JOB 53 Gertrude Ave, Perth

Reviewed for Code Compliance
Inspections Division
Approved with Conditions

REQUESTED 4x12 Expansion
to ENLARGE DECK TO 12x12

JOB 53 Gertrude Ave, Portland ME  
SHEET NO. \_\_\_\_\_ OF \_\_\_\_\_  
CALCULATED BY "i" \_\_\_\_\_ DATE 2-16-17  
CHECKED BY \_\_\_\_\_ DATE \_\_\_\_\_  
SCALE 1/8" = 1'

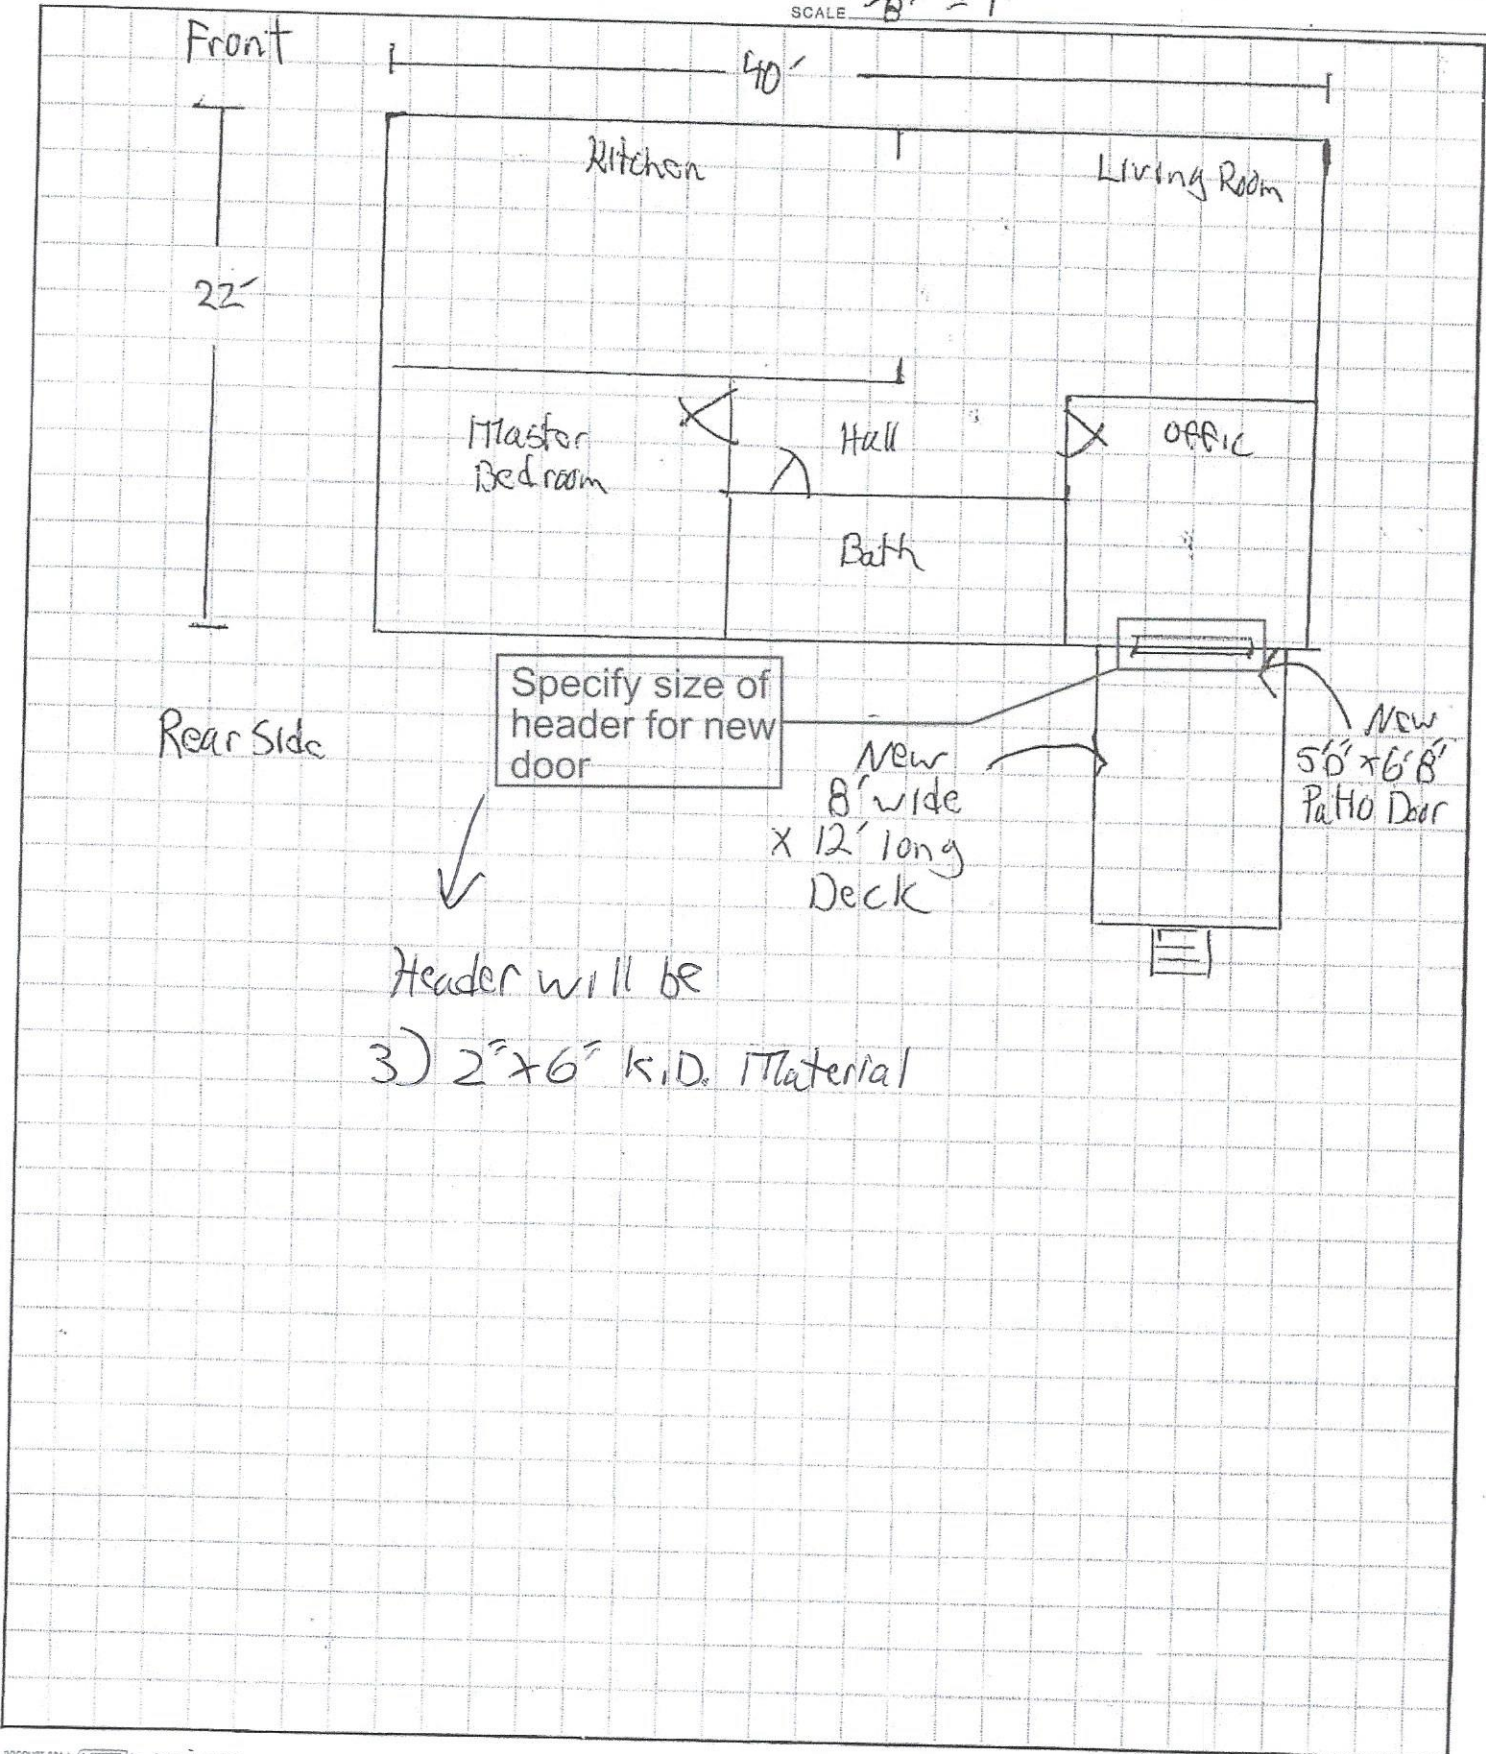
Specify size of header for new door

Header will be
3) 2" x 6" K.D. Material
